Application No: WA/50/20/RES
Site Address: Former Lanes End House West Walberton Lane Walberton BN18 0QS
Description of works: Approval of reserved matters following outline consent WA/26/18/OUT for appearance, landscaping, layout & scale for the demolition of 1 No. dwelling & the erection of 6 No. dwellings (resubmission following WA/7/19/RES).

Thank you for your internet representation made on 29th October 2020 which has been recorded as an objection with the comments as follows:

PLOTS 1 AND 2 FLOOR PLANS AND ELEVATIONS

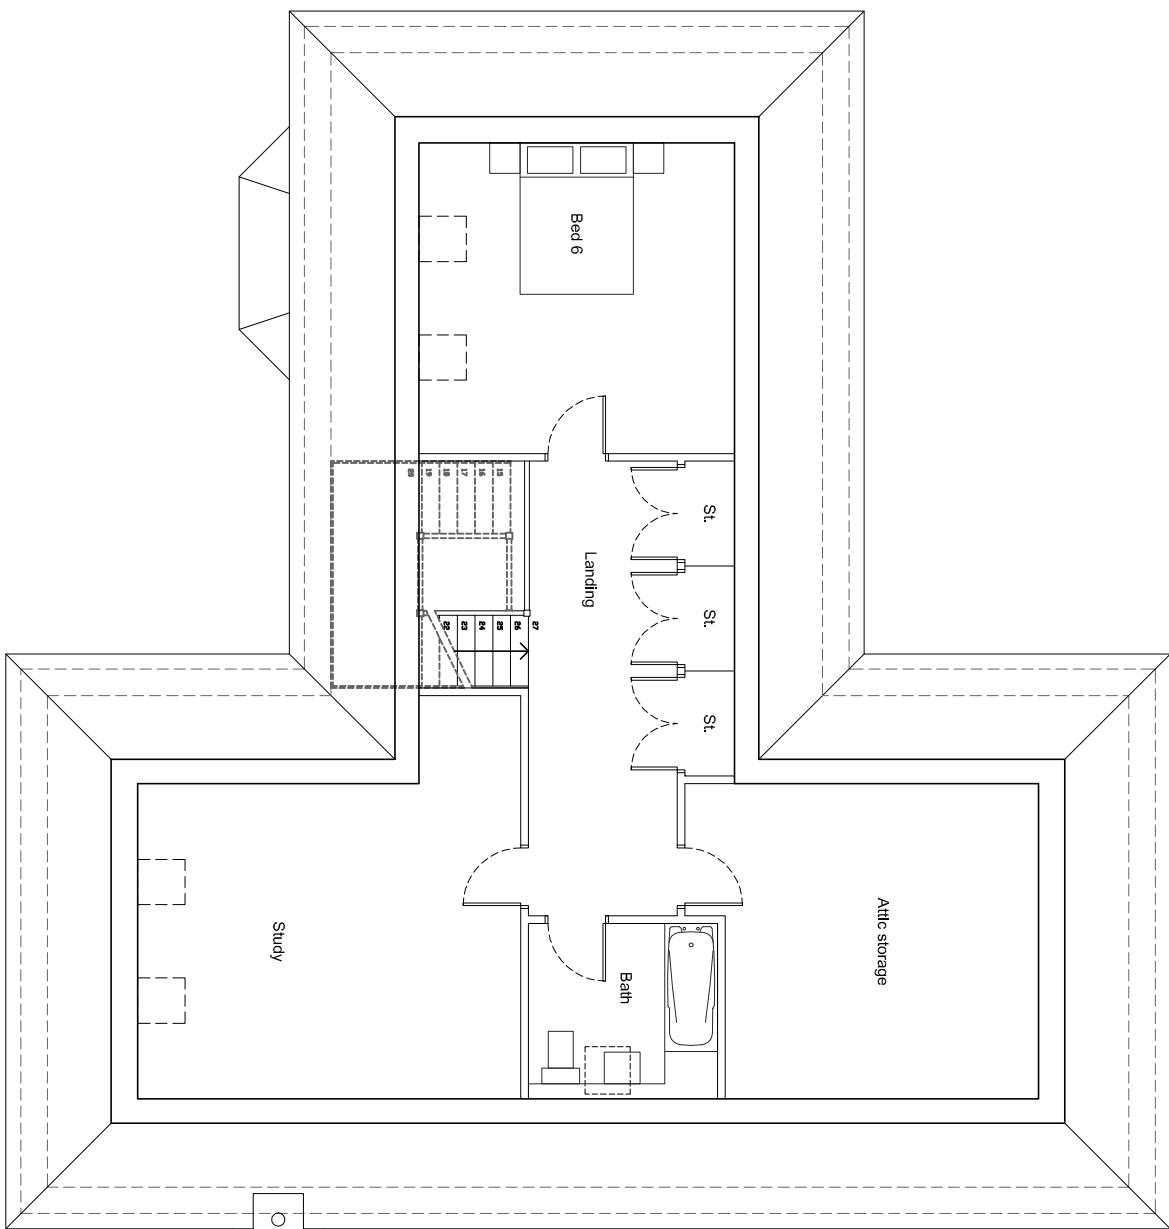
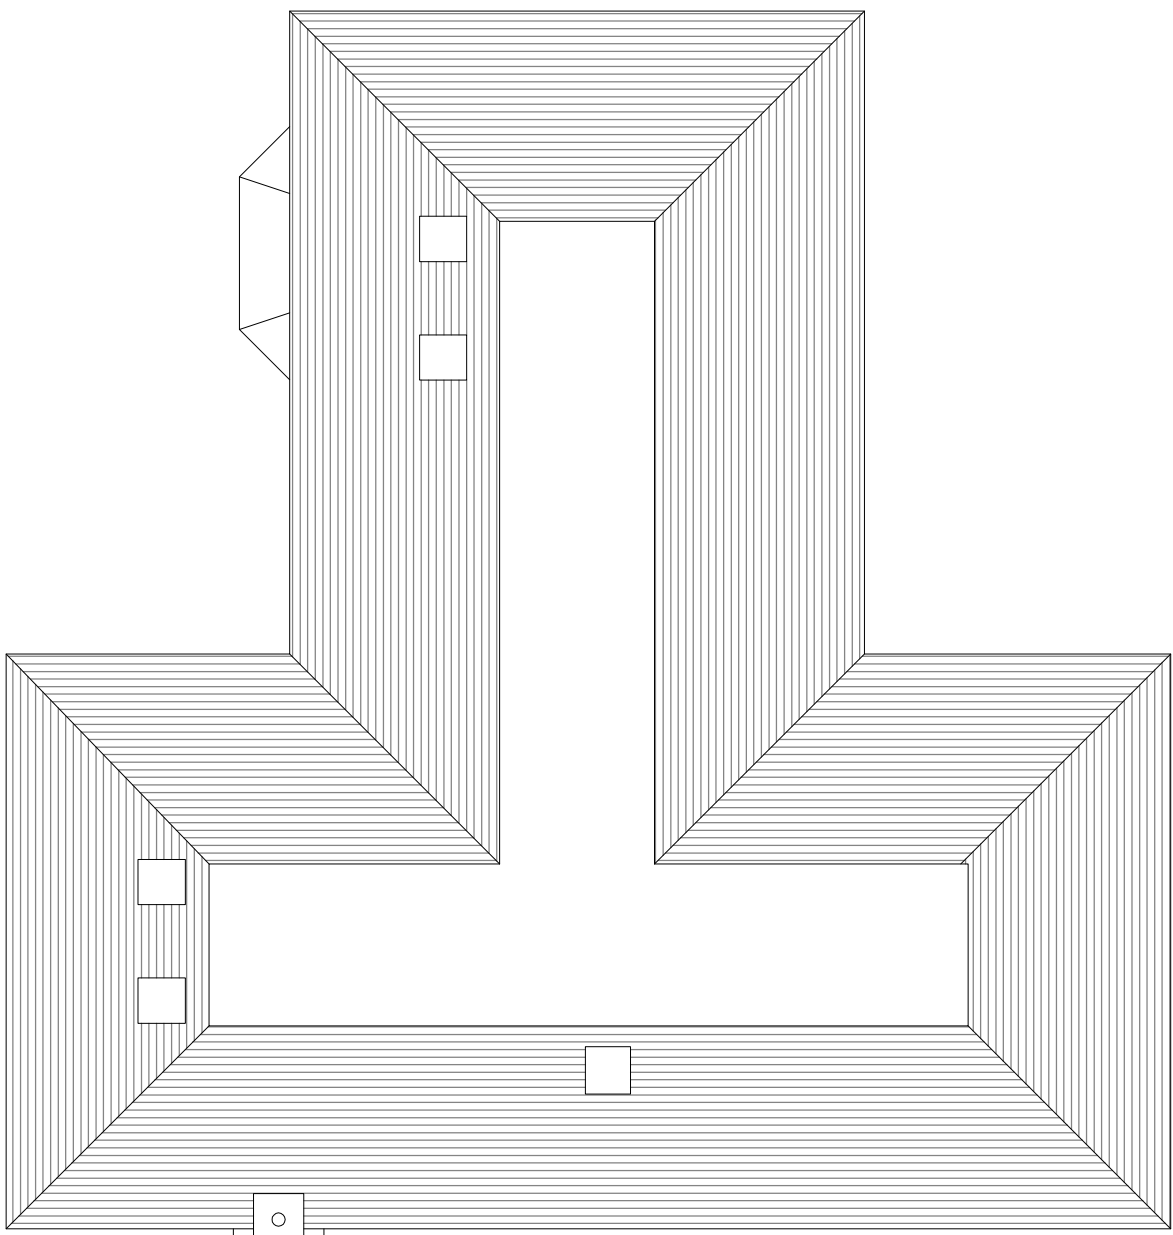
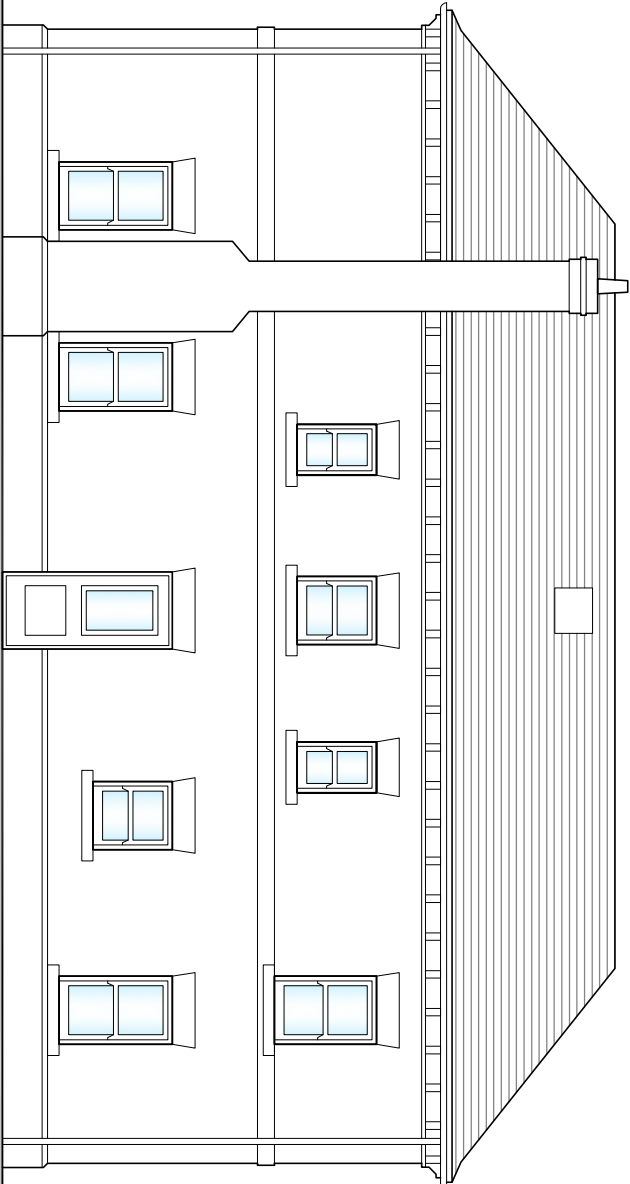
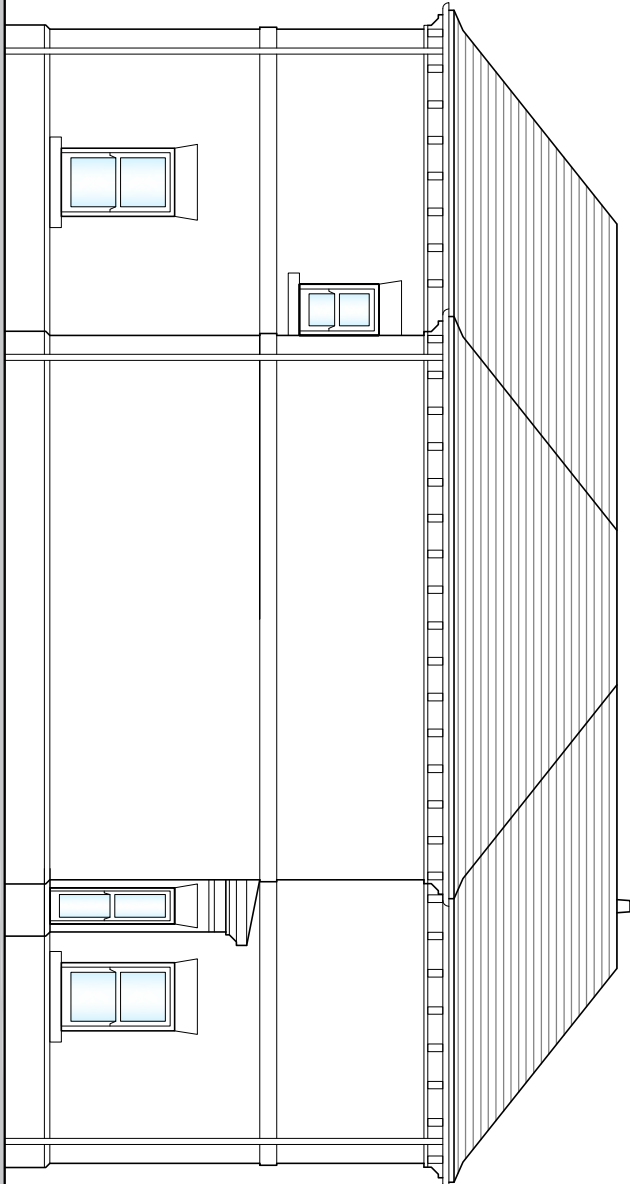
1. 3 story town house properties are totally out of keeping with the area.
2. Second floor windows of House 1 invade privacy of White Cottage. Will allow direct view into bedrooms and garden of White Cottage.

PLOT 3 FLOOR PLANS AND ELEVATIONS

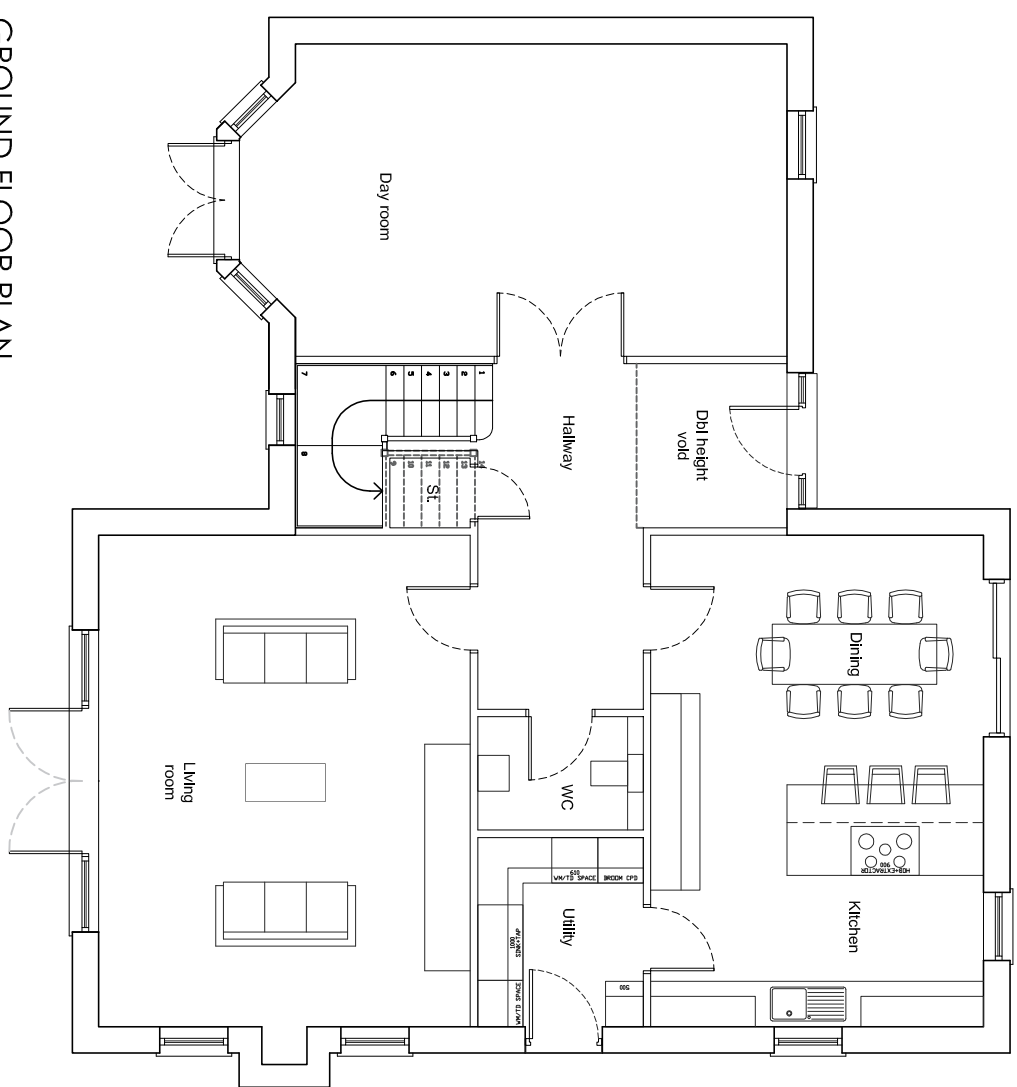
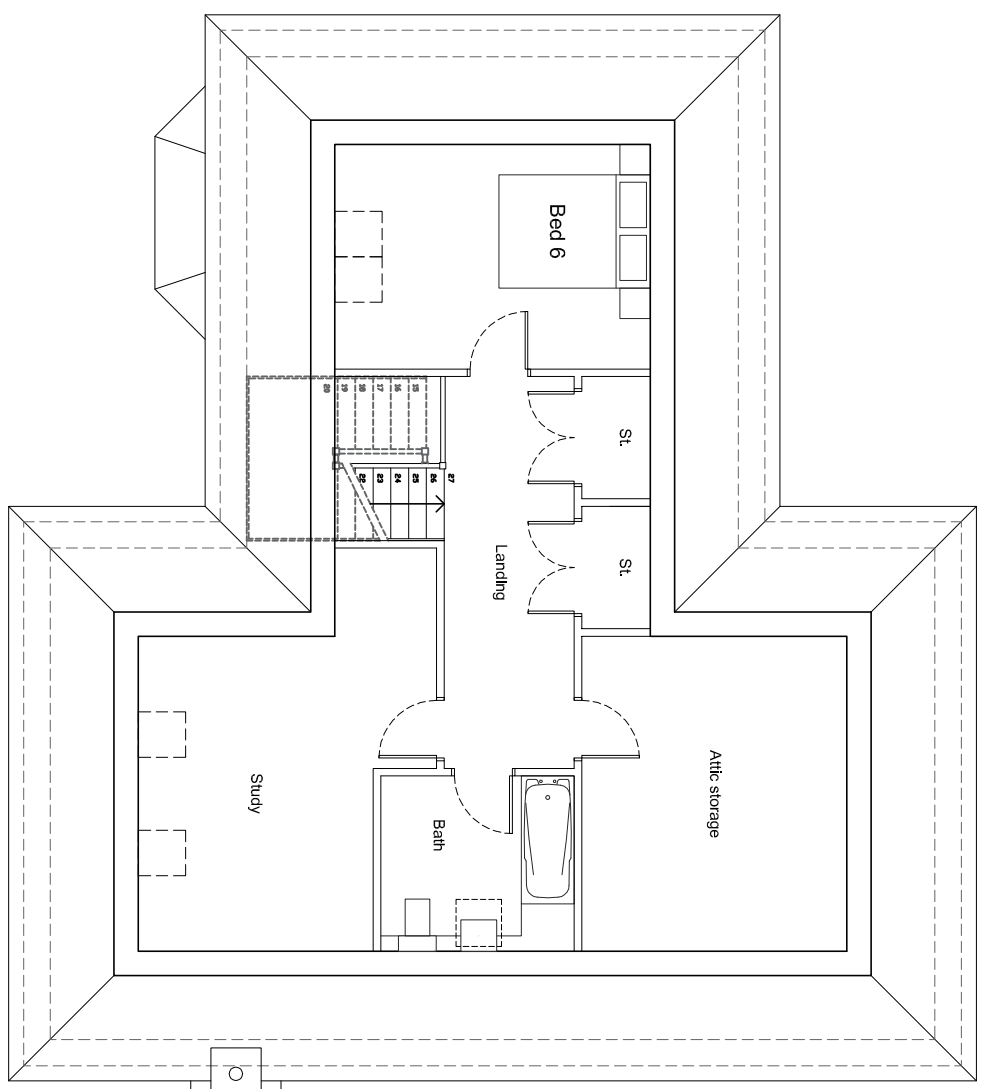
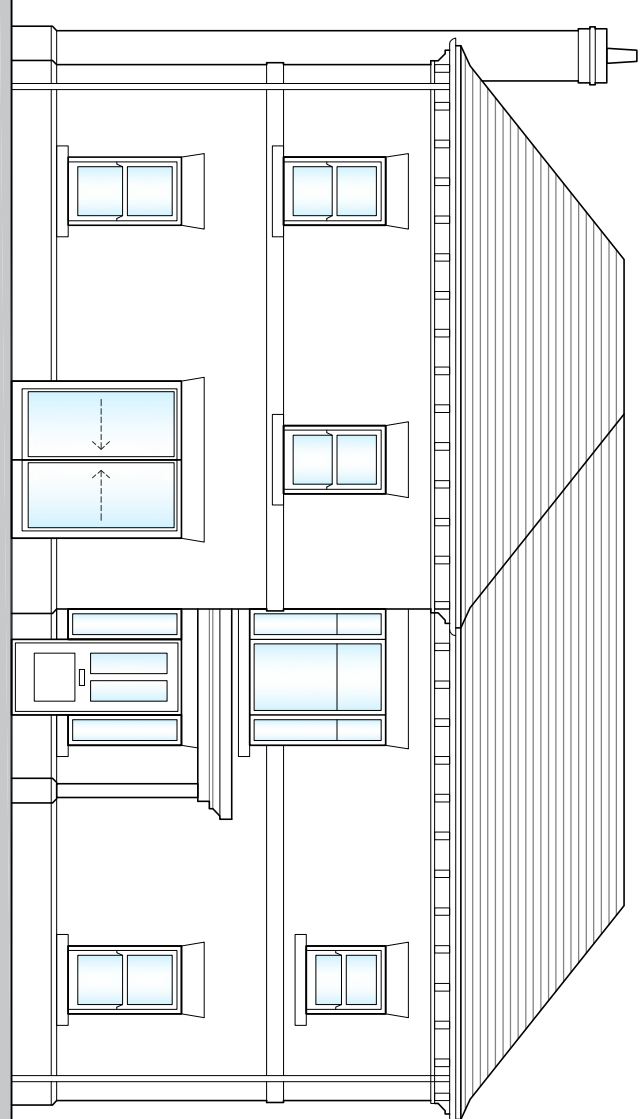
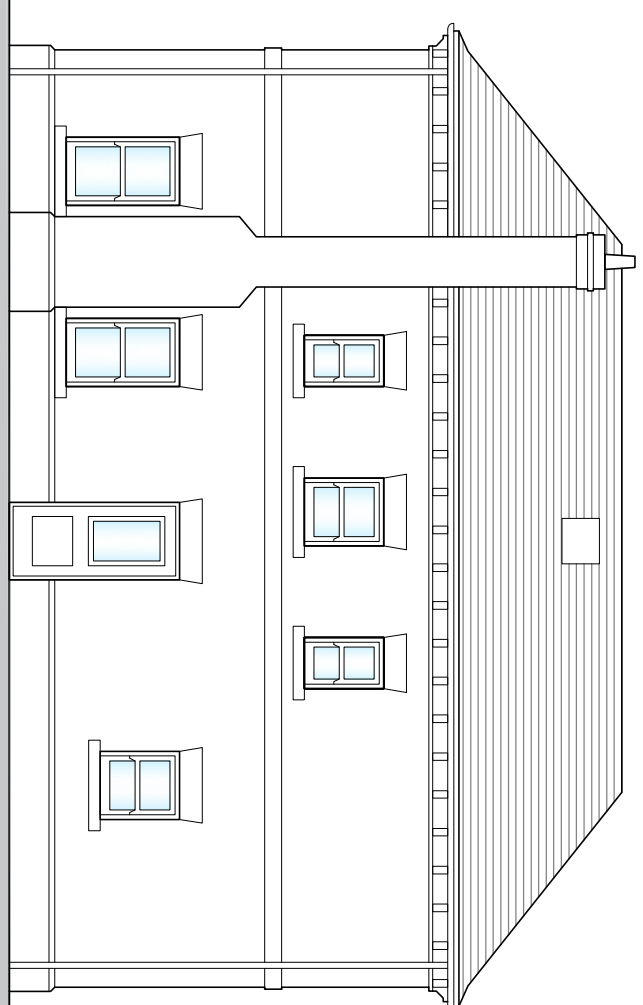
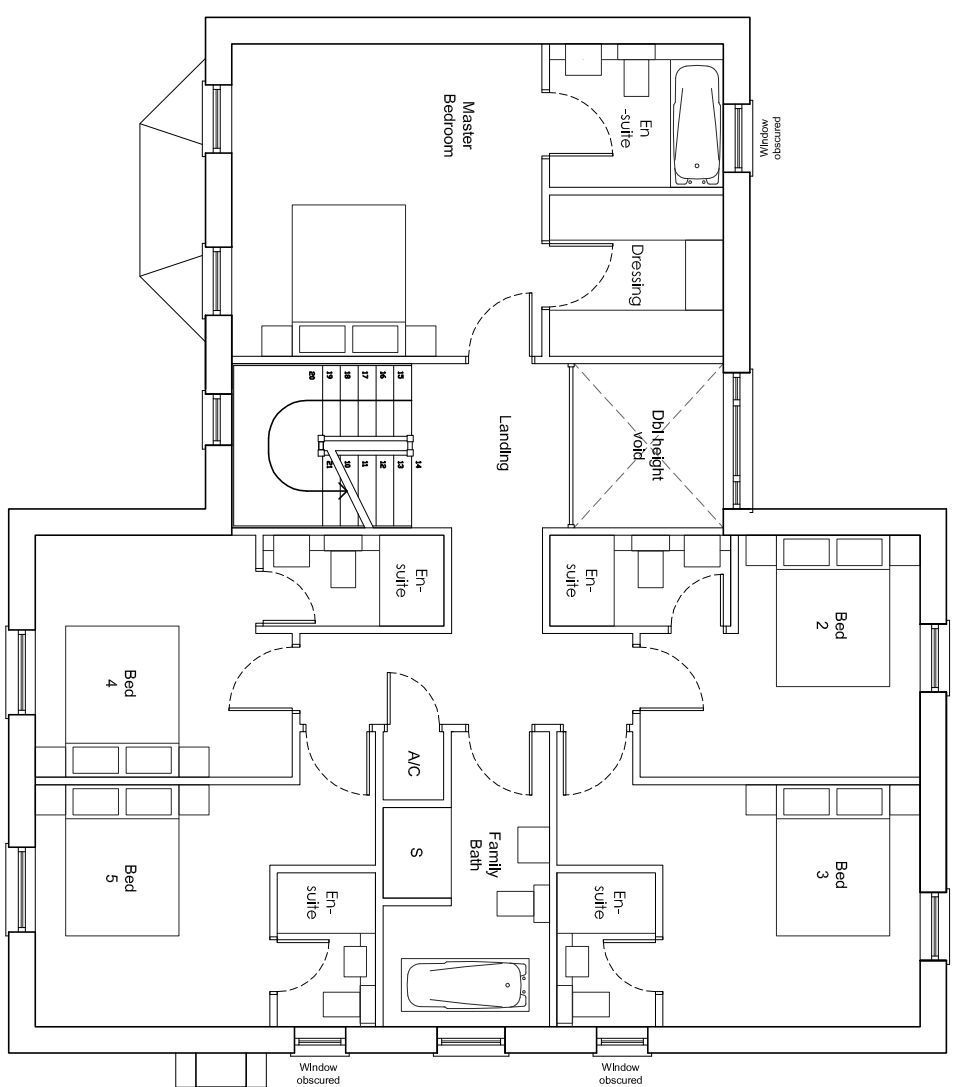
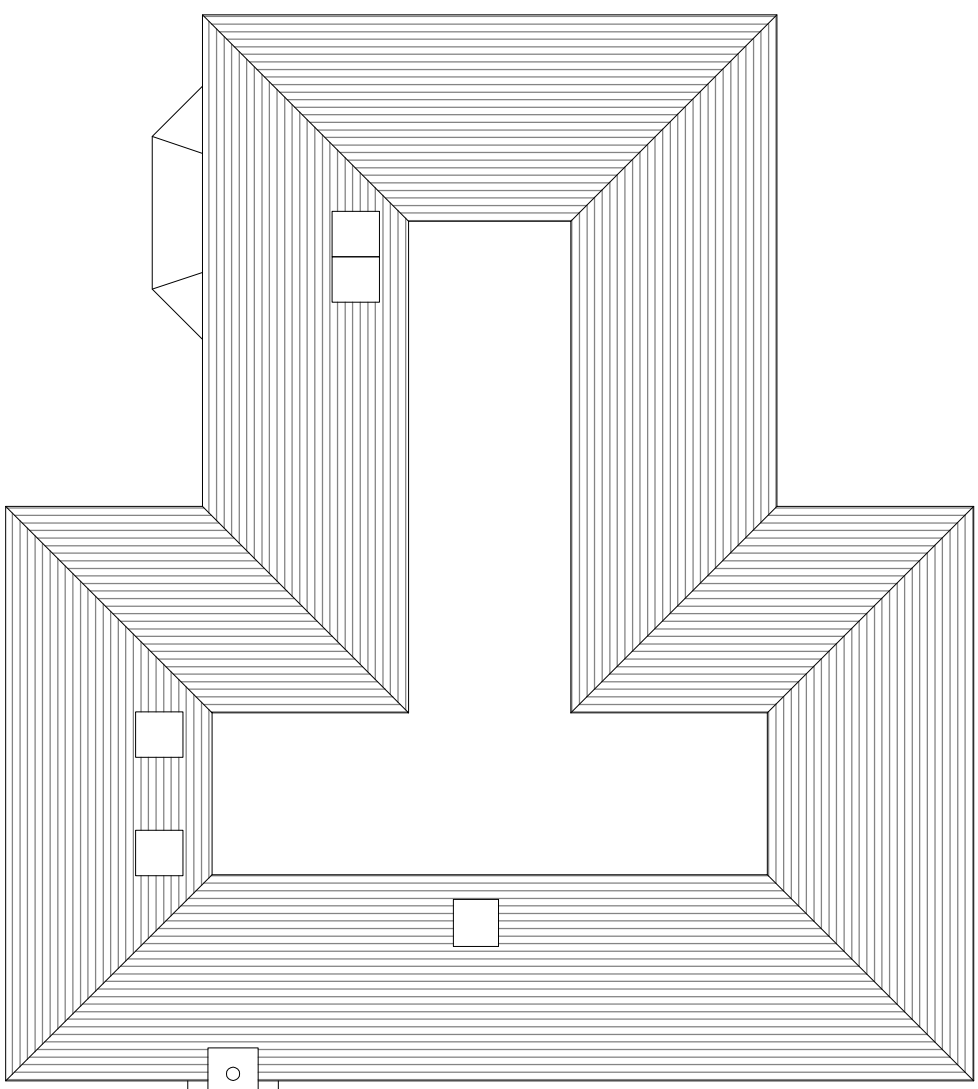
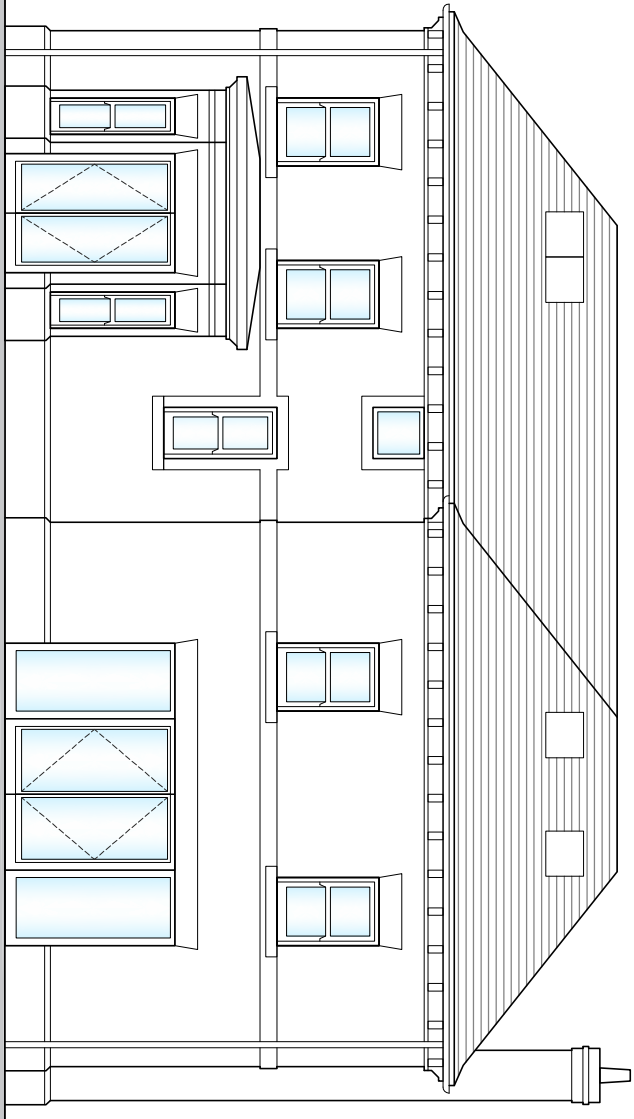
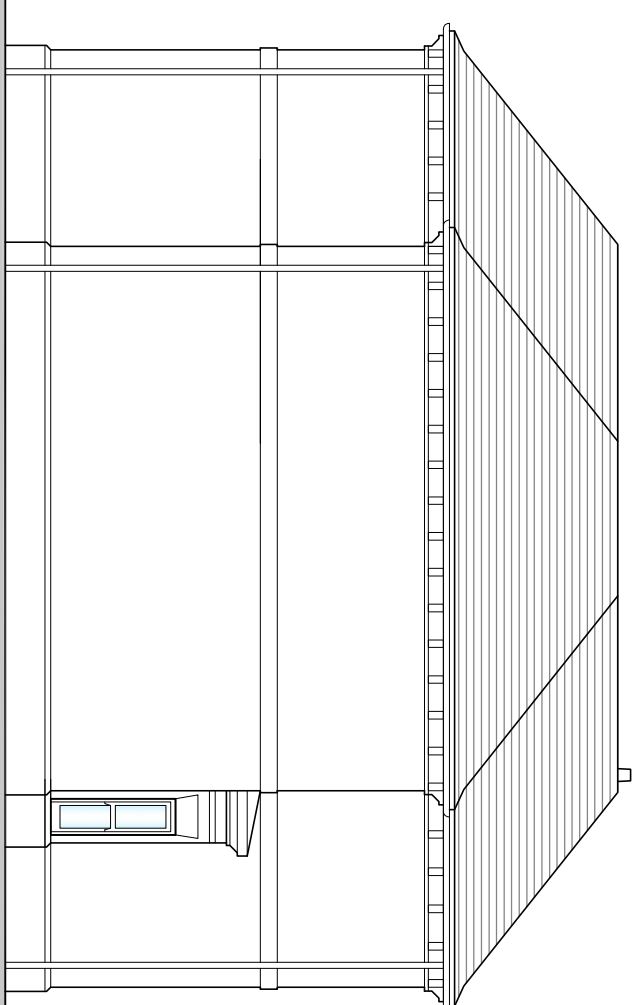
3. Garages 01 and 03 are way too close to the White Cottage boundary. Will significantly impact the feel and value of White Cottage
4. House 03 is way too close to the boundary. Plan is marked as 8811mm from boundary but this is NOT the closest point to the boundary
